V11_GEC Plans.pdf Markup Summary

Subject: Callout
Page Label: [1] 8 GRADING & EROSION CONTROL PLAN
Author: CDurham
Date: 2/15/2024 11:48:31 AM
Status:
Color: ■
Layer:
Space:

EARLY GRADING & EROSION CONTROL PLANS  
 GRANDVIEW RESERVE FILING NO. 1  
 FOR  
 HR GREEN

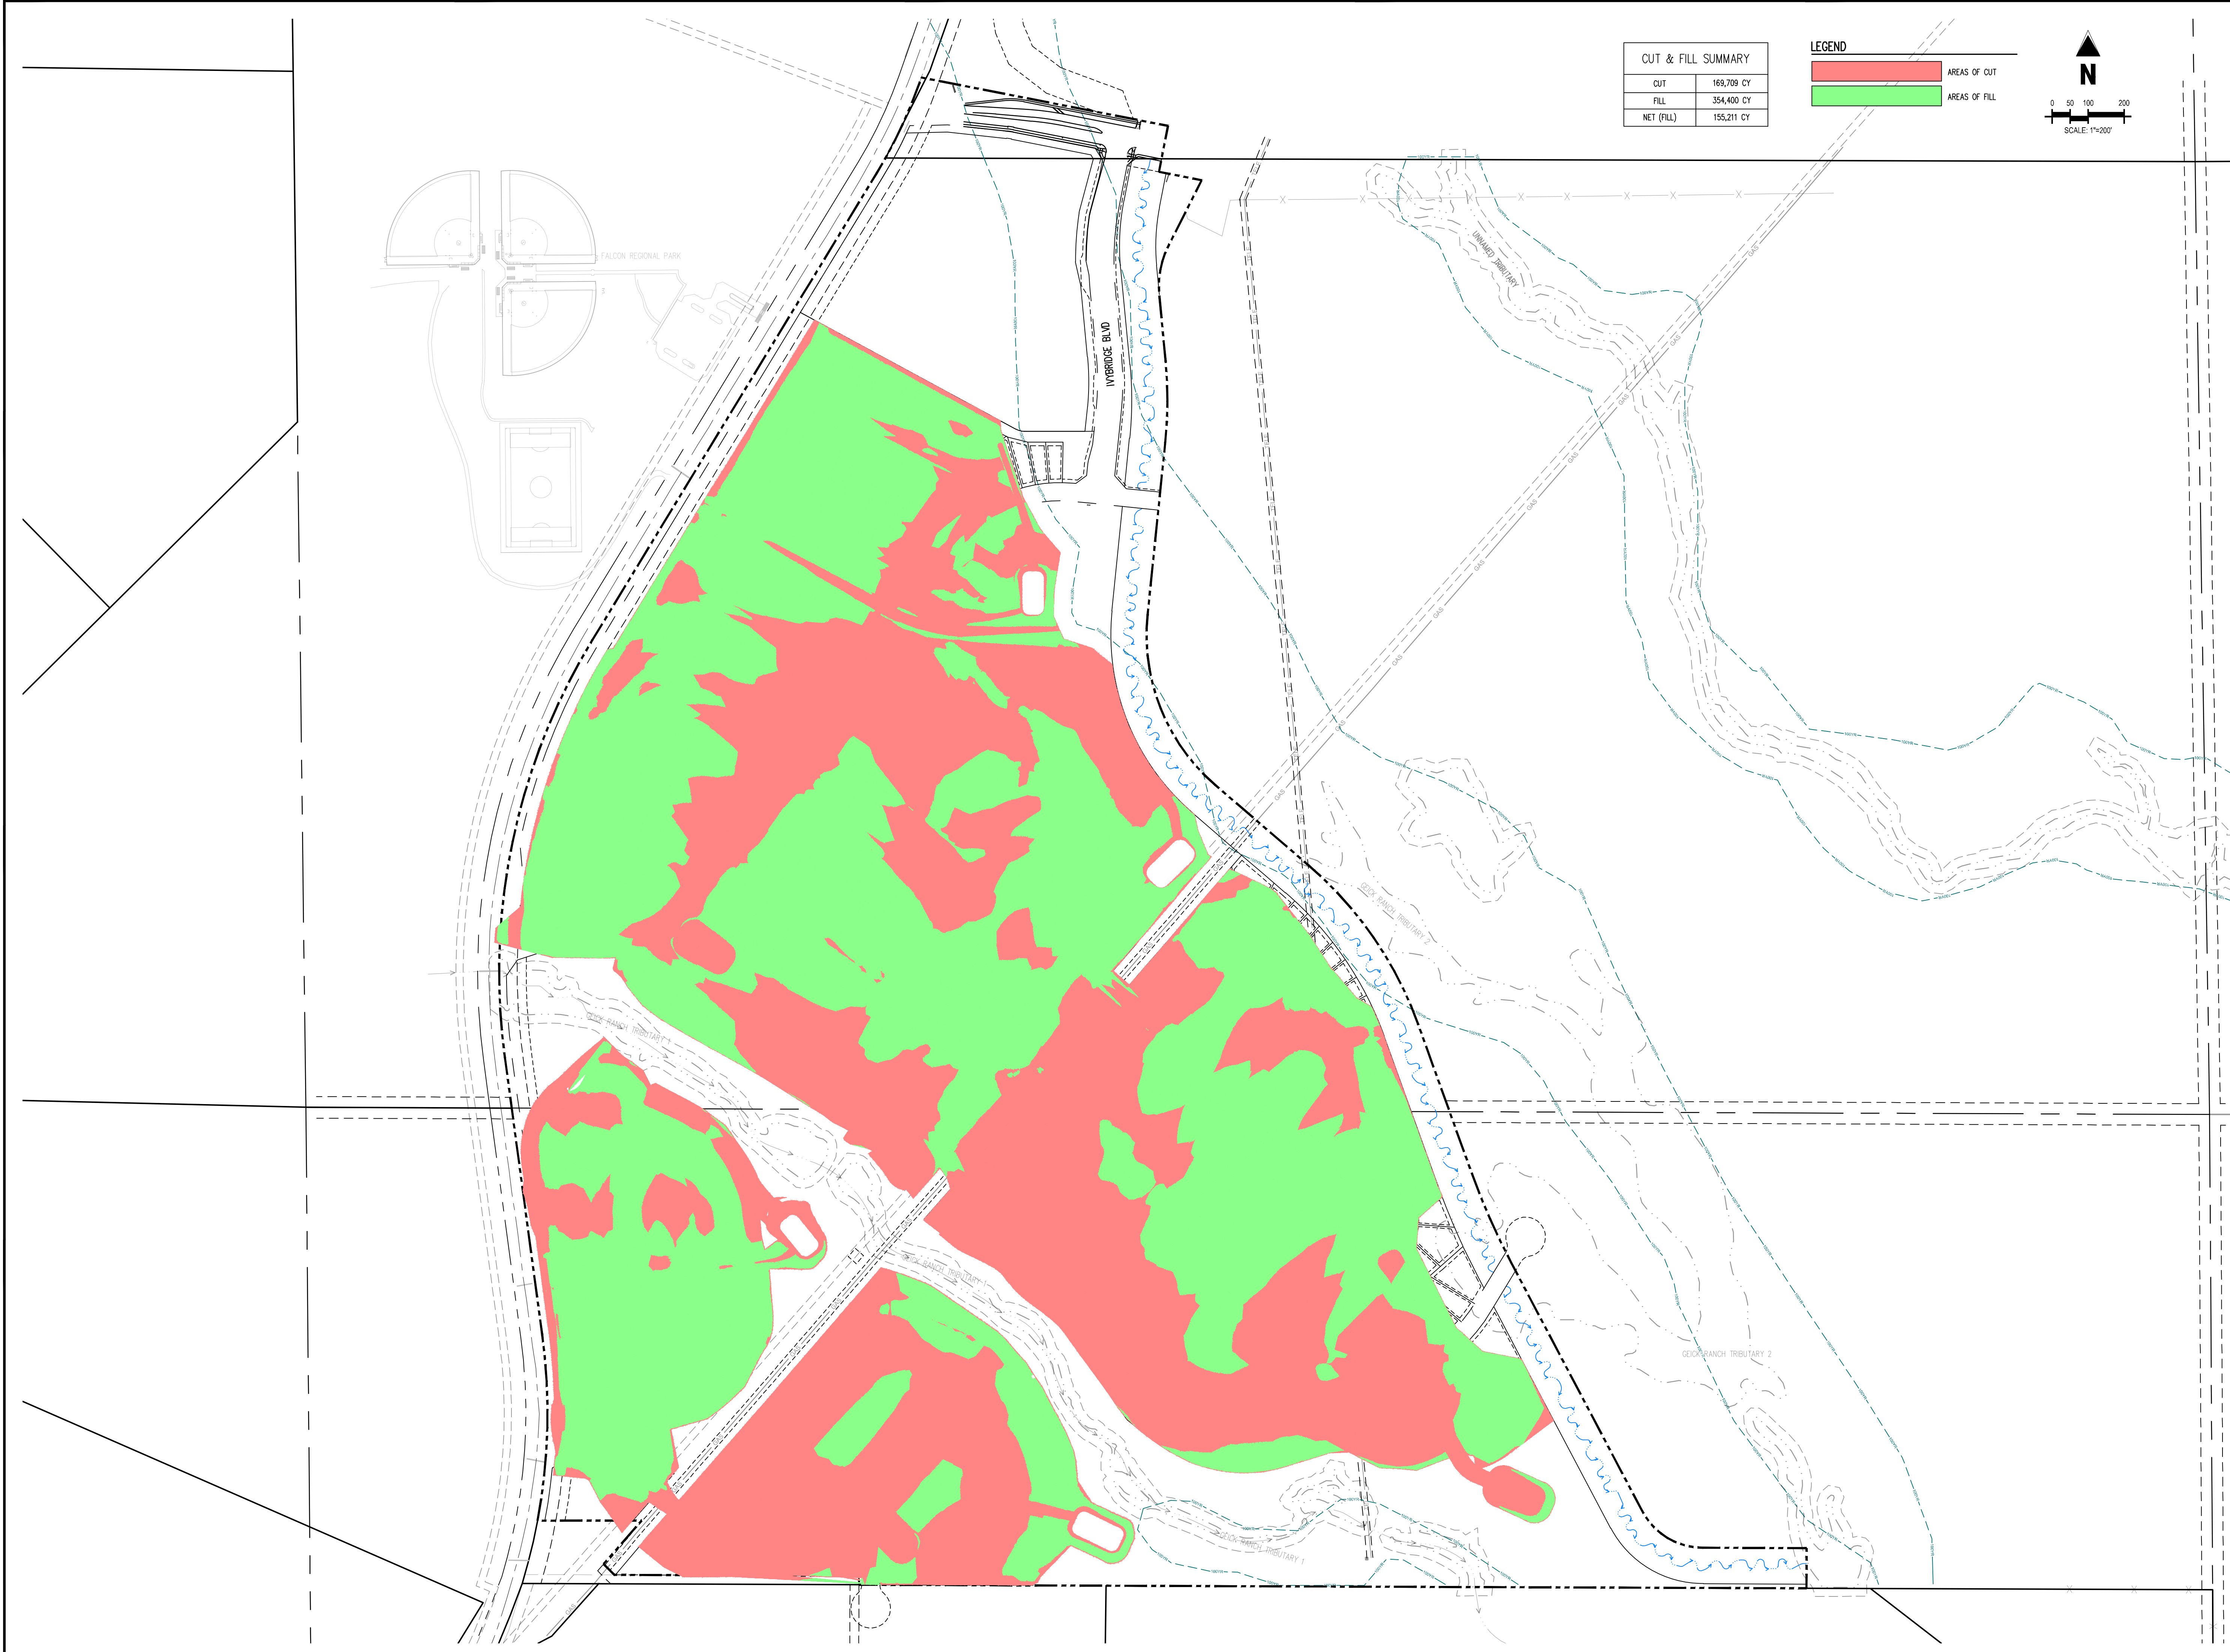
Why is the swale not in line with the culvert? How will culvert flows be conveyed to the swale?

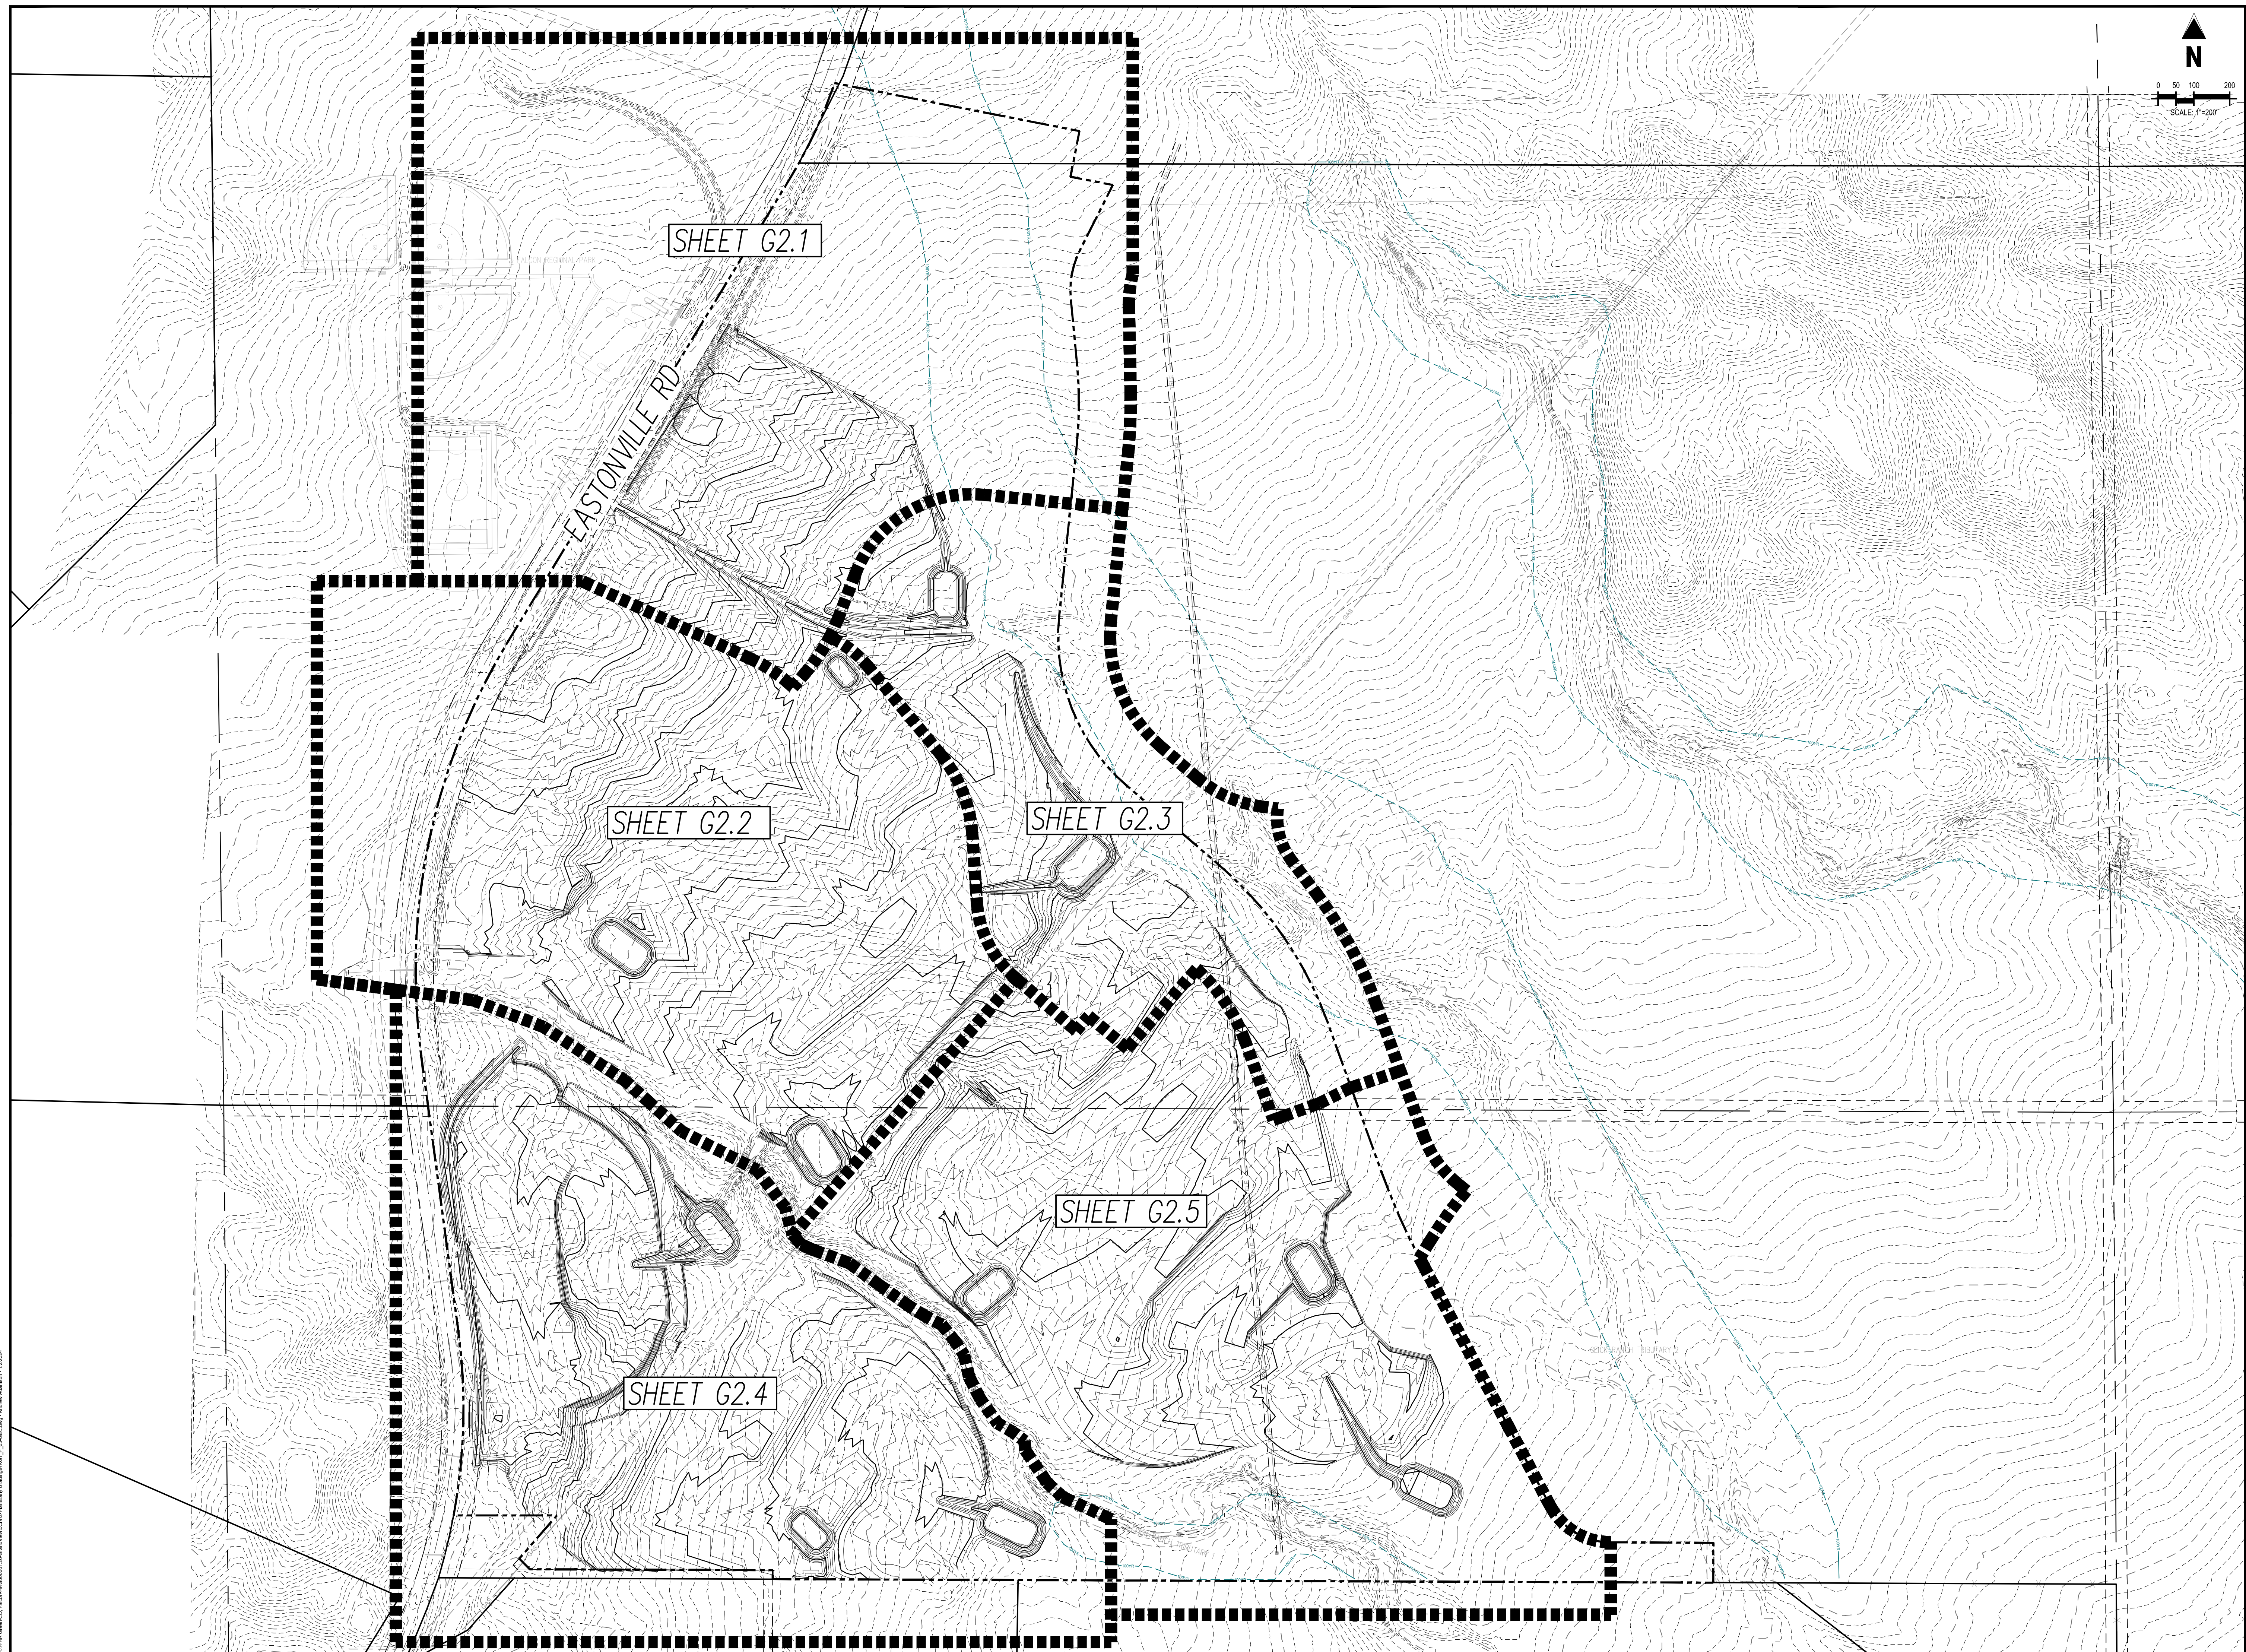
Silt fence can not be used to direct flows.
Reconsider location or type of BMP needed here.

Riprap is shown in this swale on Sht G2.1 but not on this plan. Revise to remove discrepancy and to provide adequate erosion protection.

Consider need for riprap apron here or other means of outfall protection. Silt fence is not a suitable temp BMP for the outfall of a swale.
